Crown Castle
200 Spectrum Center Drive
Suite 1700
Irvine, CA 92618

RE: WCF21-036, 8215 SE 78th St, Mercer Island

I am providing the additional materials requested in response to your compliance review letter dated January 4, 2022, for the following referenced Application. Below I will note each item listed on the review as missing or incomplete and provide a response to satisfy each item of record.

SHEET TITLE: POLE ELEVATIONS  
 SHEET NUMBER: A1.2  
 PAGE: 3 OF 7  
 PLOT SCALE: 1:1 @ 24"x36"; 1:2 @ 11"x17"

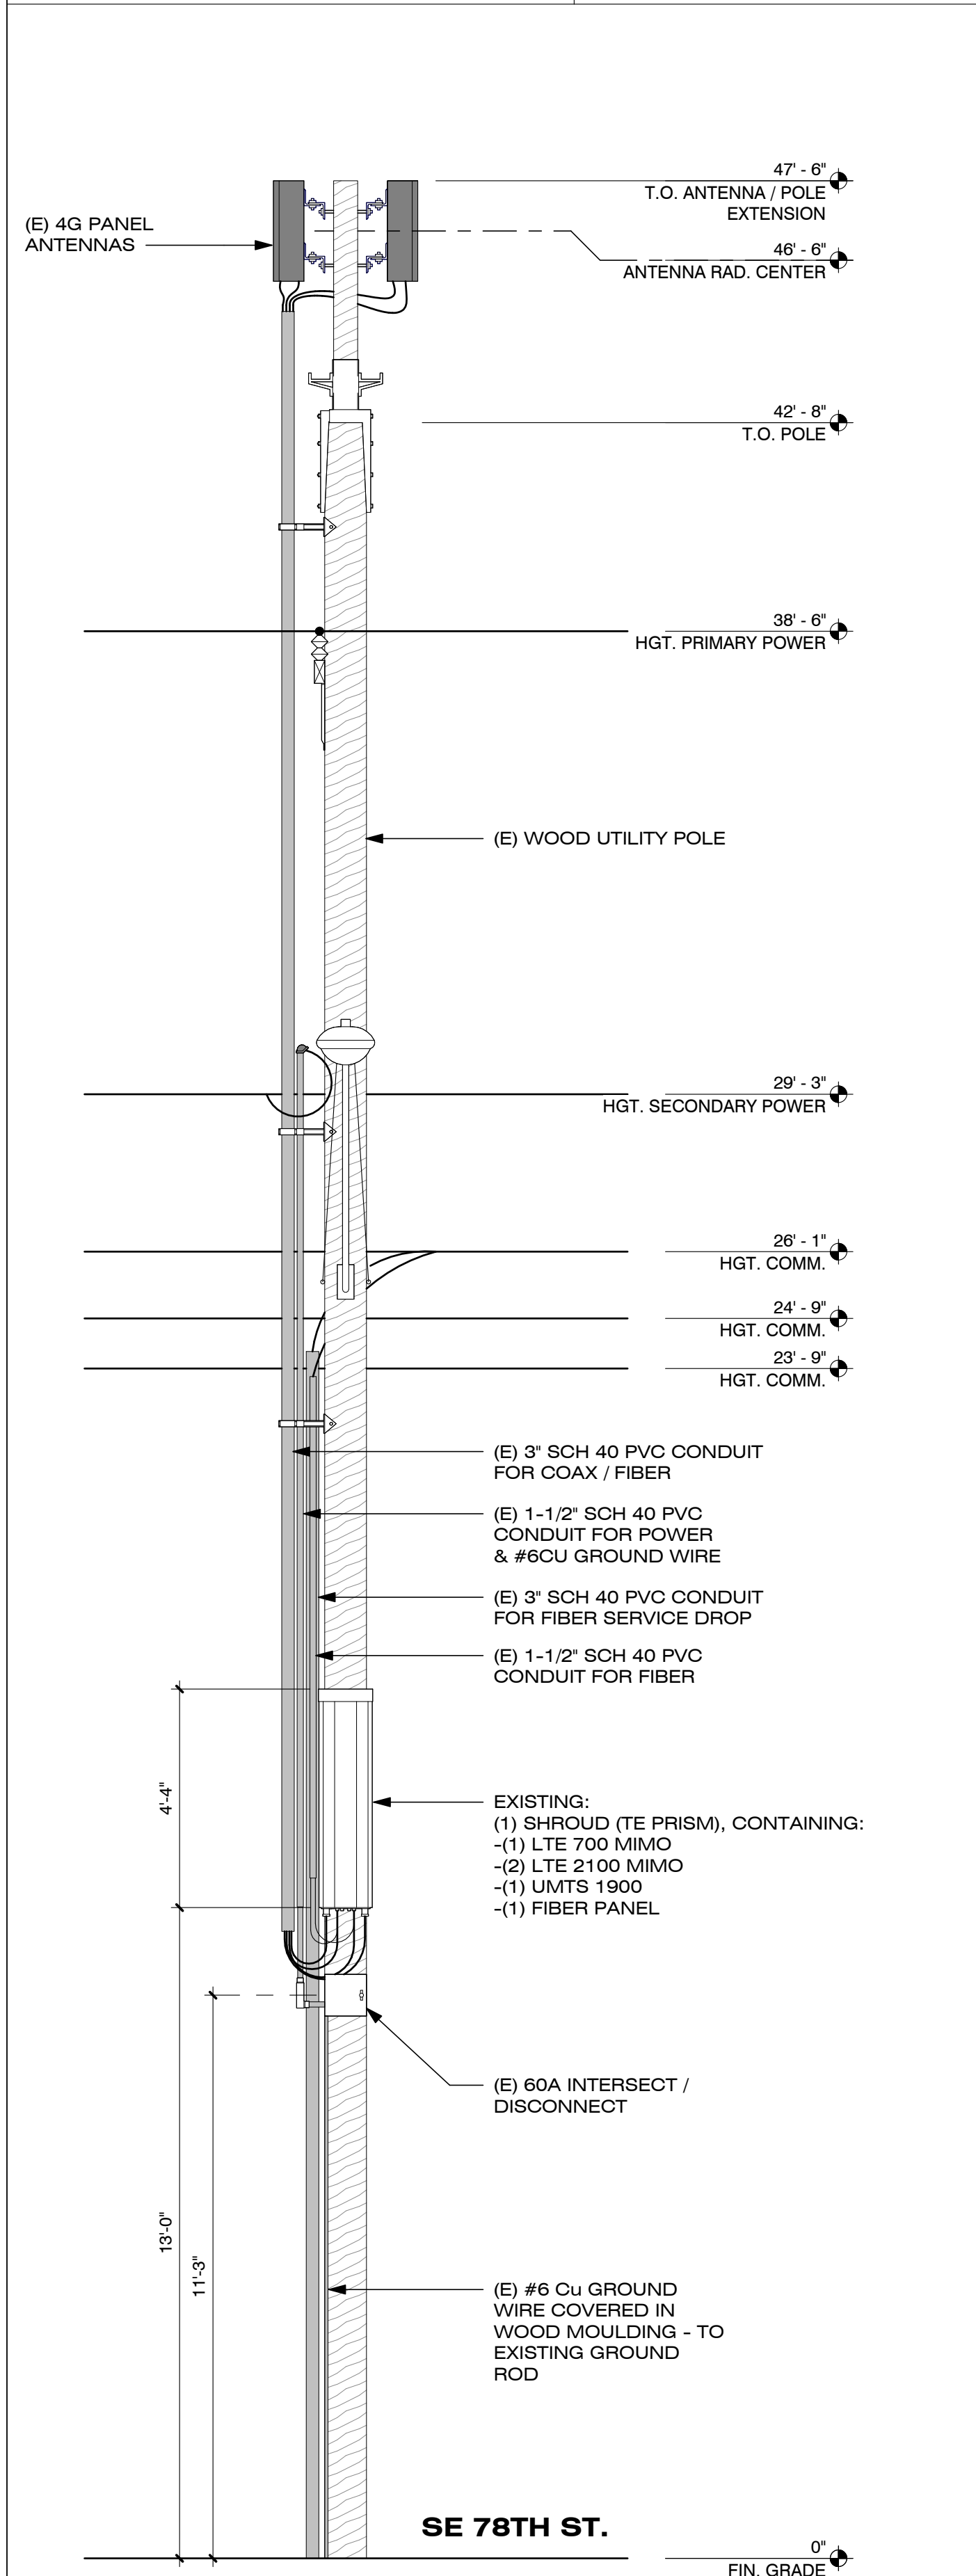
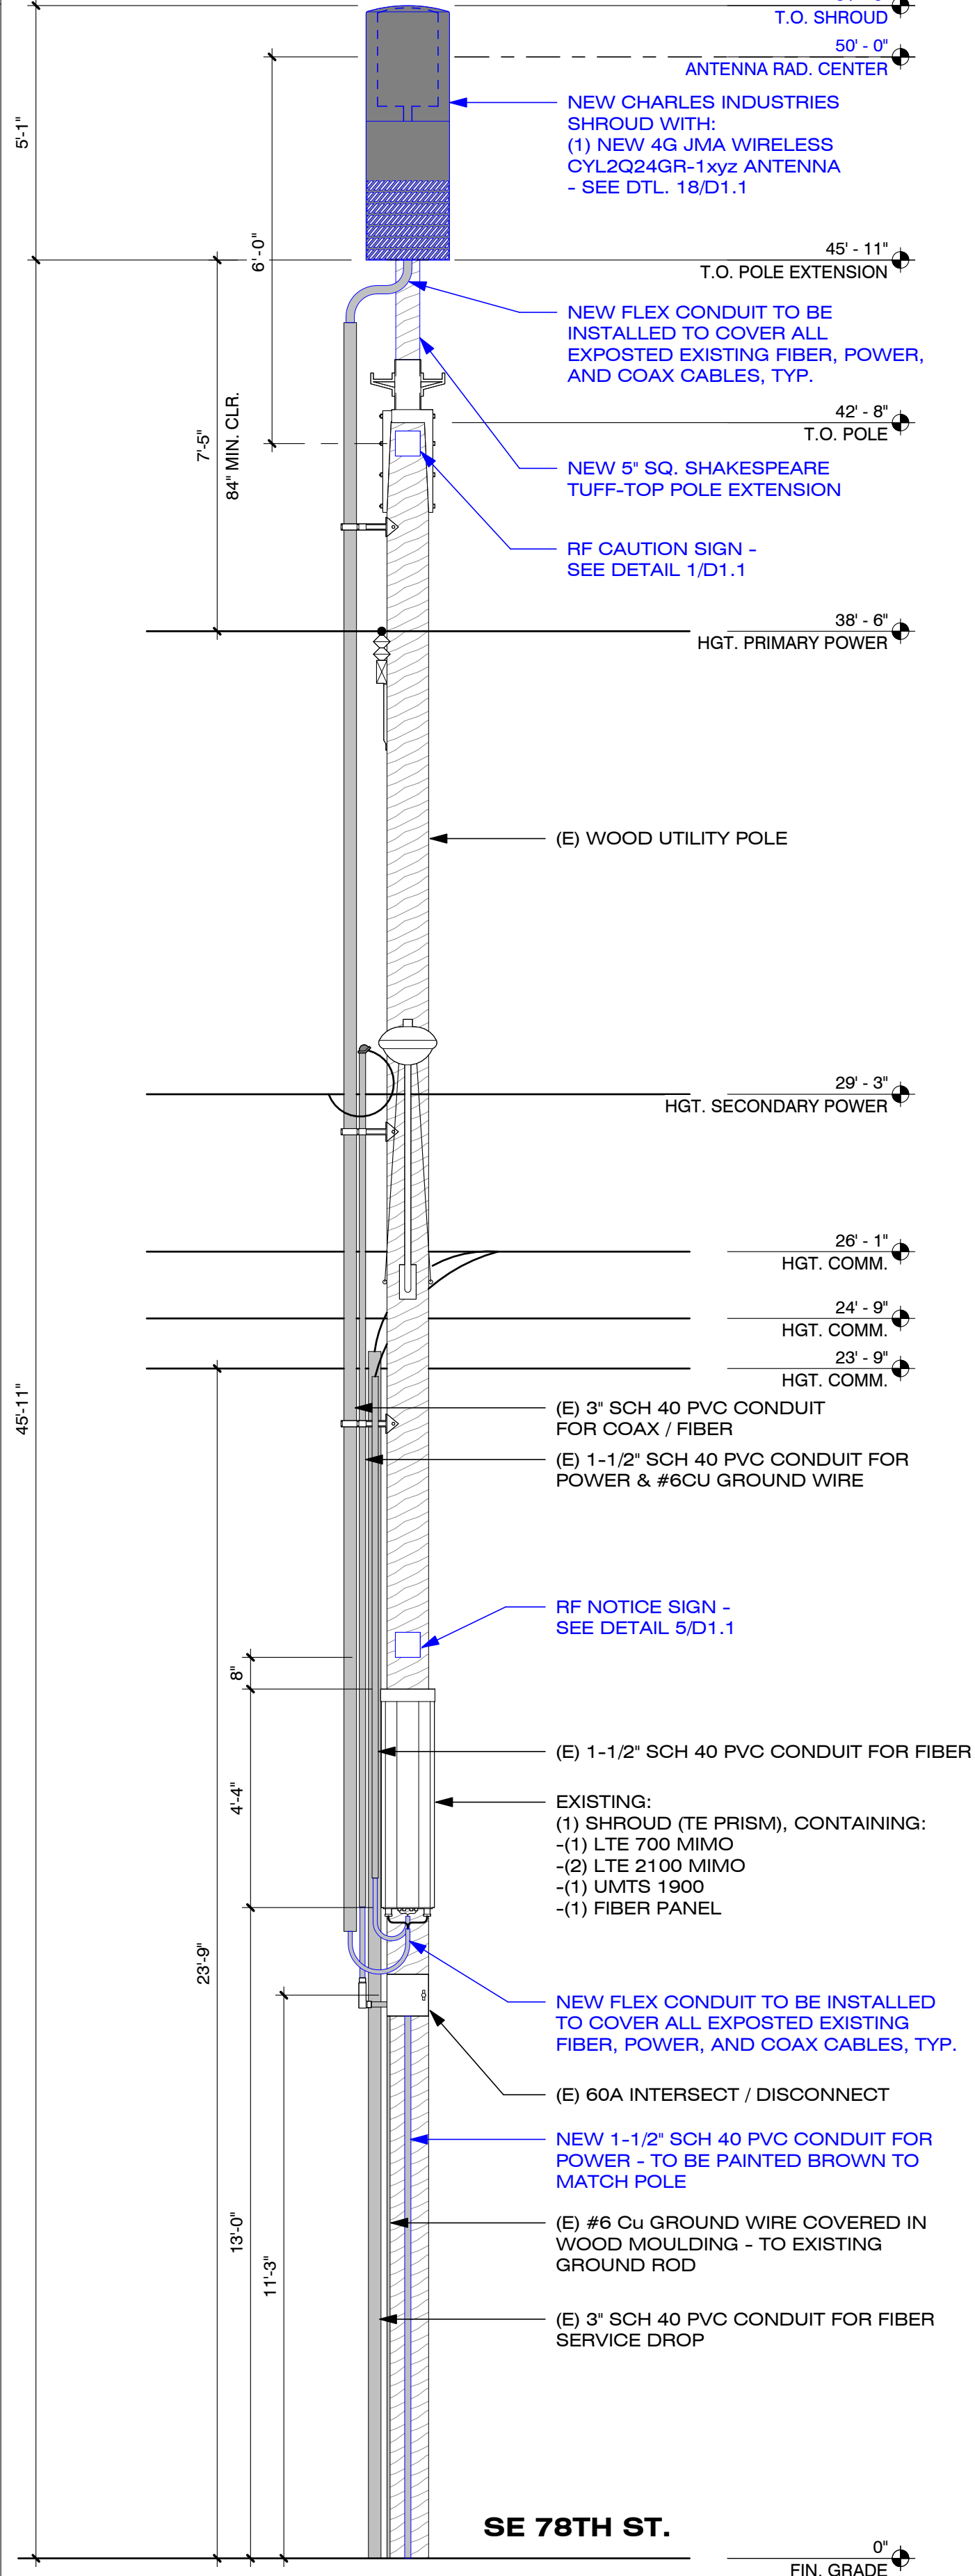
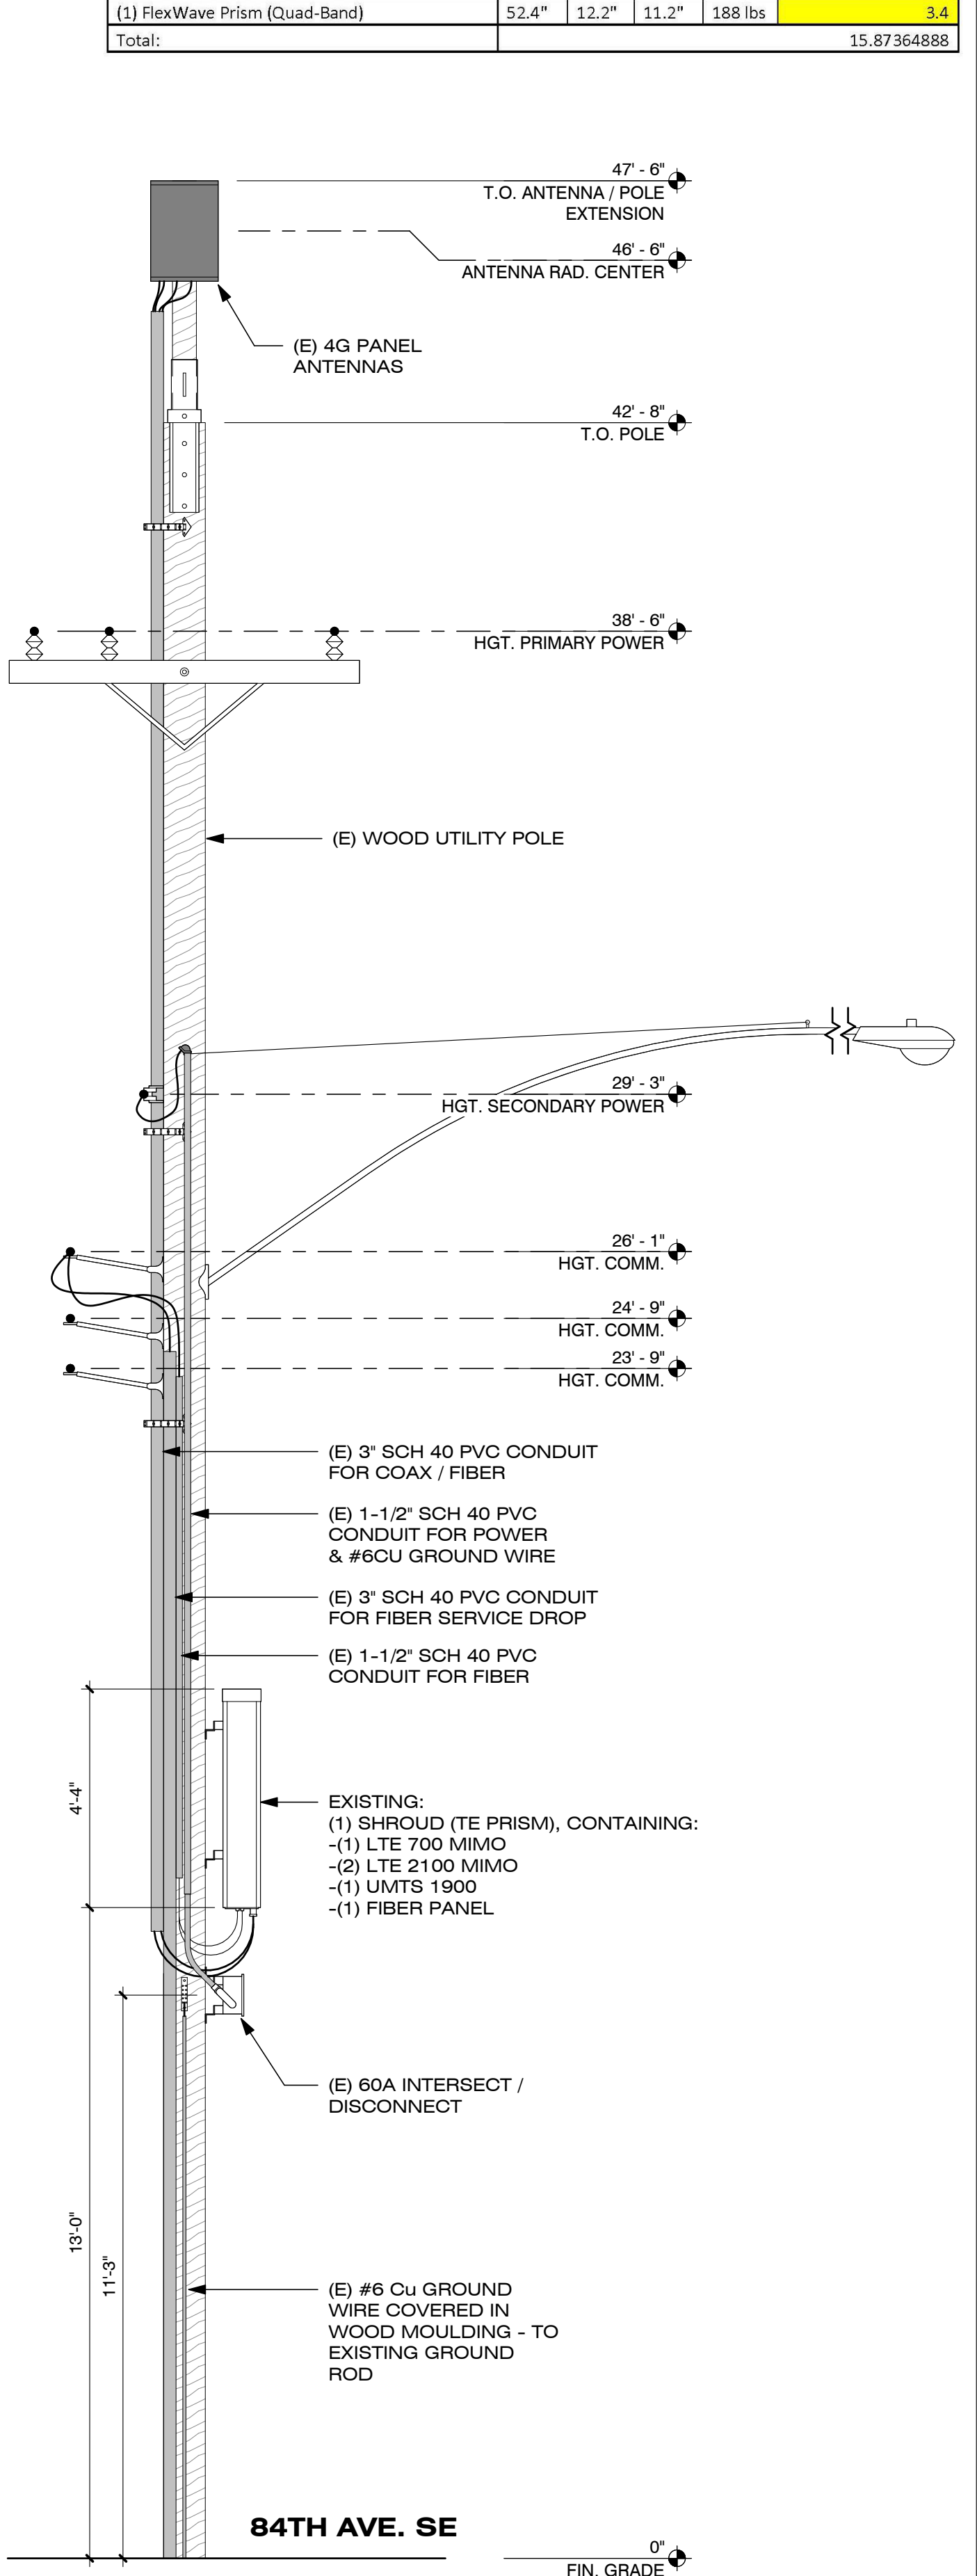
- 3. MICC 19.06.075(C)(13) requires all cables and wires to be routed through conduit along the outside of the pole. The provided plans show that the facility's wires are proposed to be exposed between the top of the main conduit and the antennas and between the bottom of the main conduit and the equipment cabinets. In the new application for a modification to an existing small cell facility, please revise the plans to show that all cables and wires will be contained within conduit from the antennas to the equipment cabinets.**

Crown Response: Please see revised construction drawings (A1.2, D1.1).
